Telephone: 01282 475579  
Fax:  
Email: Jason.lancaster@lancashire.gov.uk  
Your ref: CONCS/3/2013/0529  
Our ref: JDL/DC3/3/2013/0529  
Date: 03<sup>rd</sup> July 2013

**PLANNING APPLICATION NO: 3/2013/0529**  
**Proposed Erection of 2 x 8m Flagpole**  
**Unit 5 Friendship Mill Whalley Road Read Lancashire BB12 7PN**

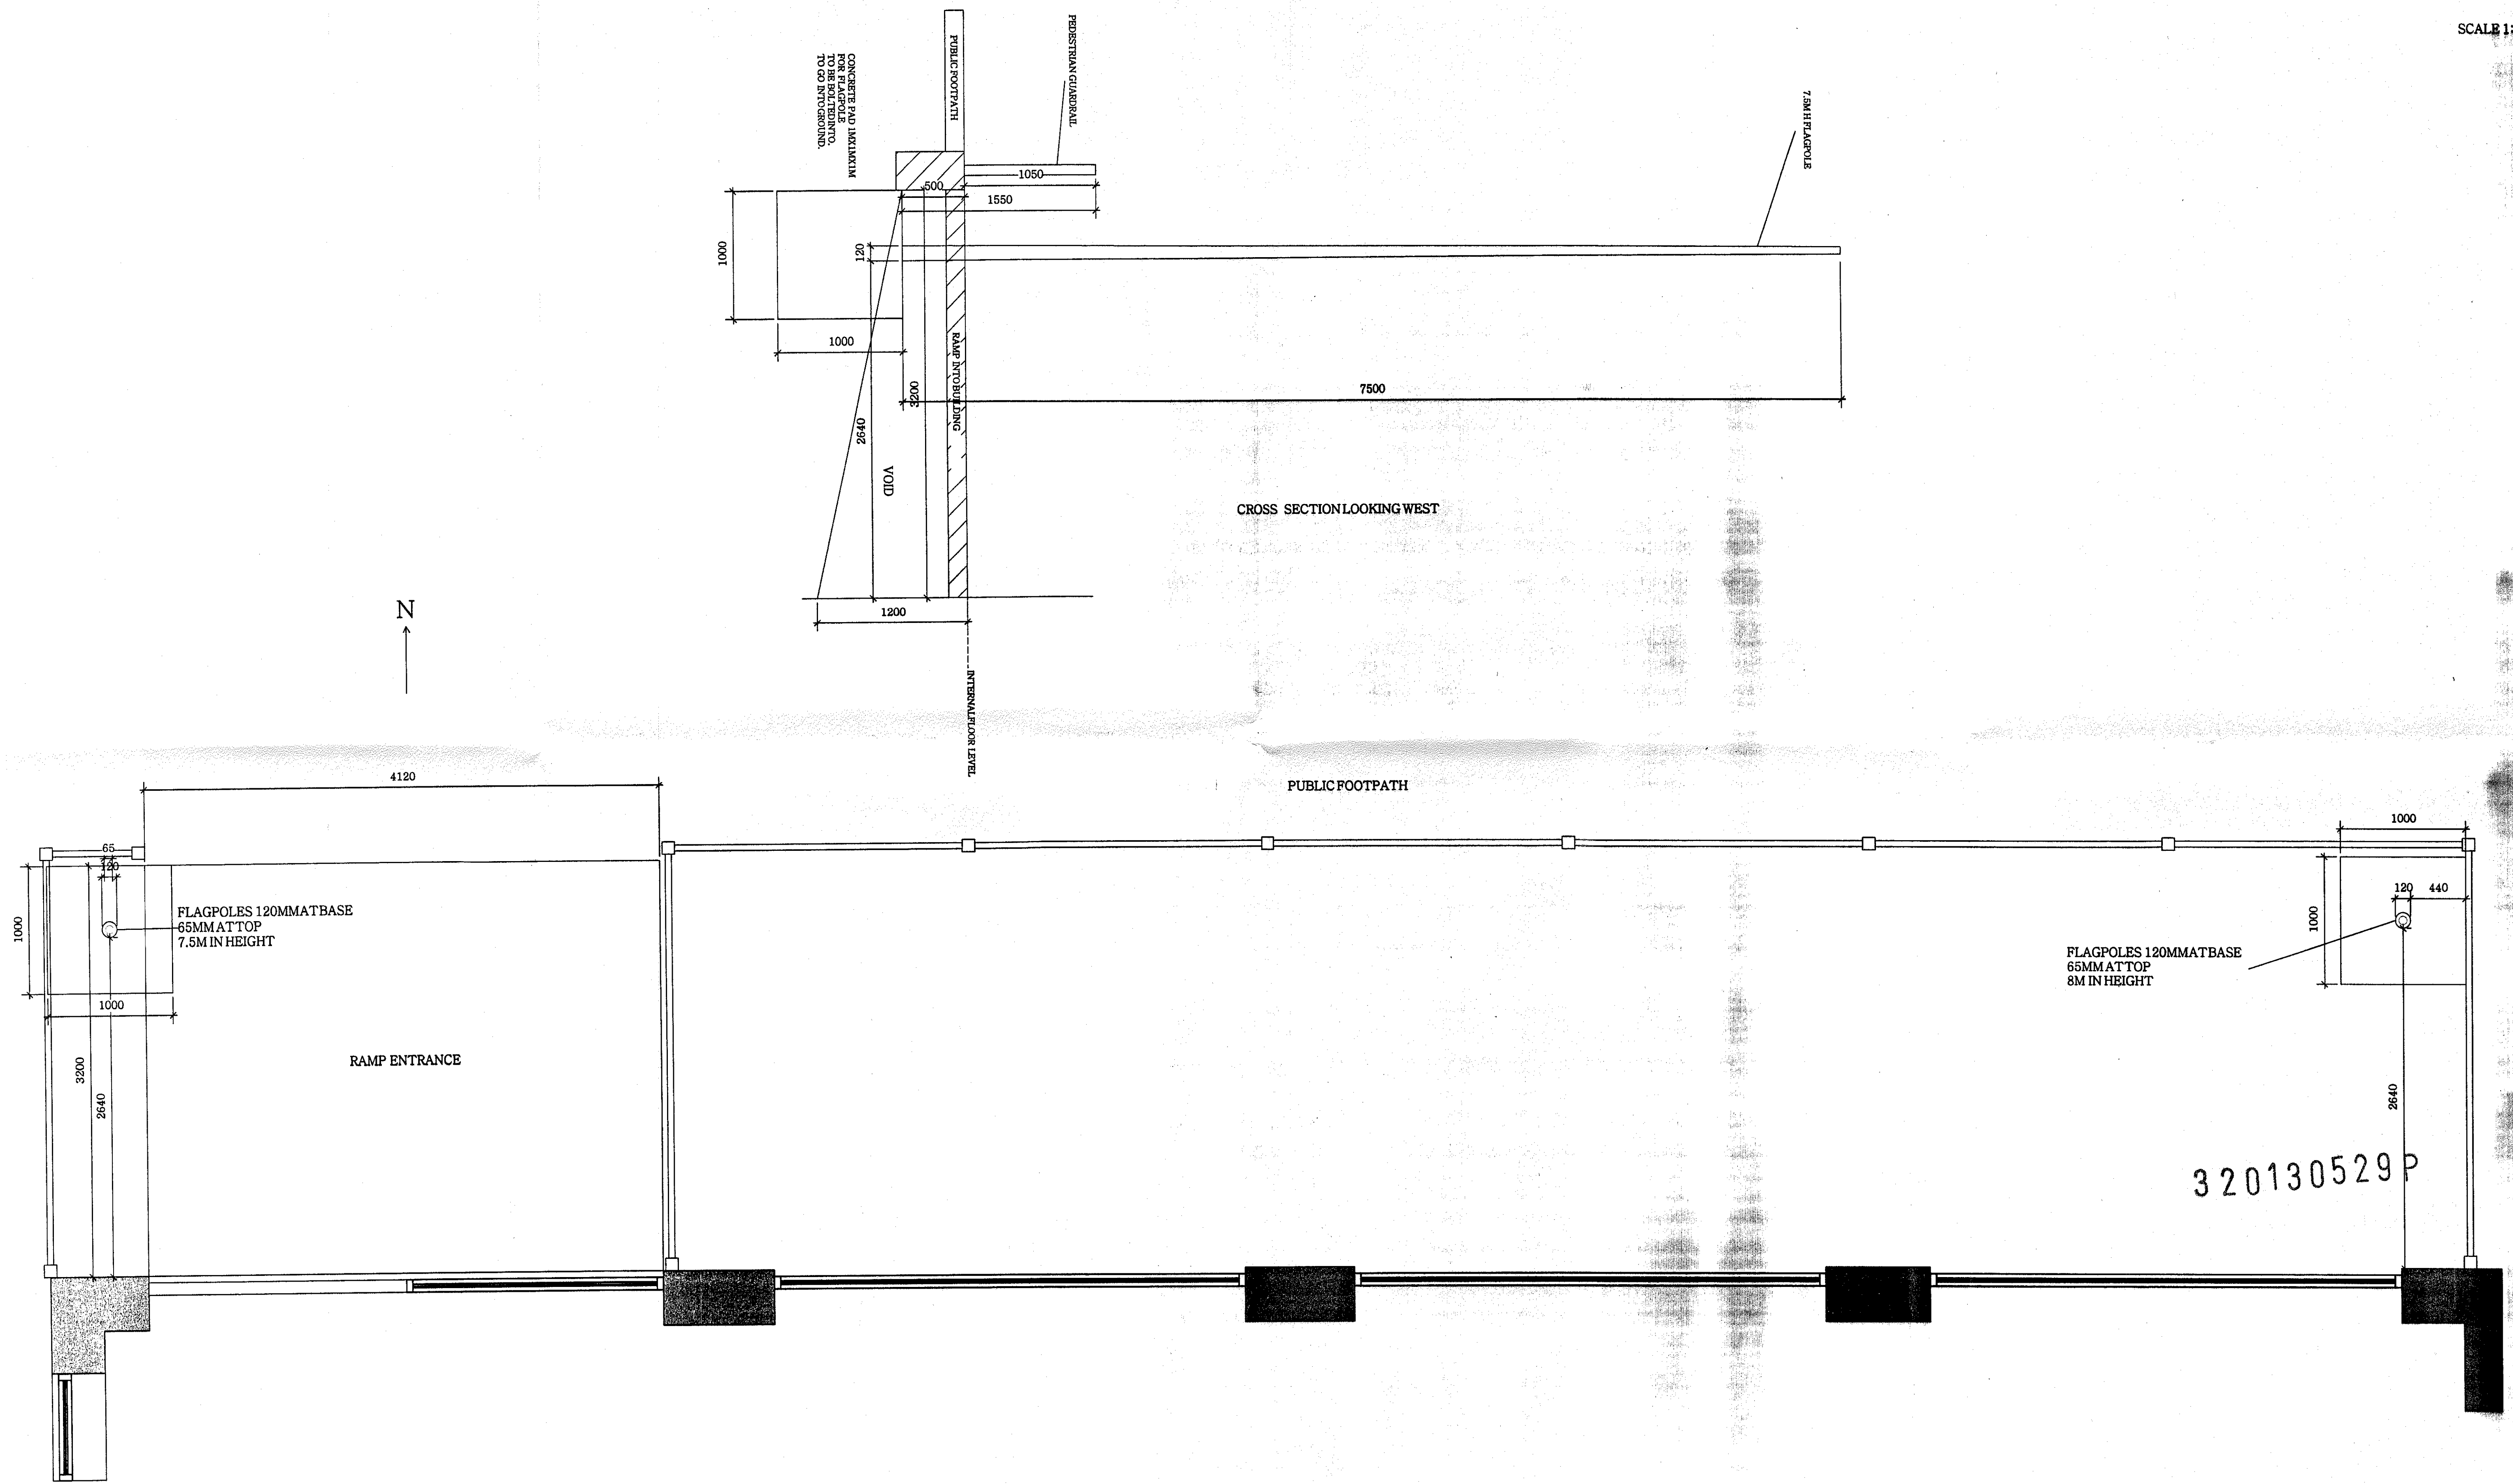
I object for the flag poles being located as they are proposed on the general layout plan as the flag would overhang the highway in their current positions.

If the flagpoles were relocated further towards the property and not overhang the highway I would have no objection to this on highway grounds.
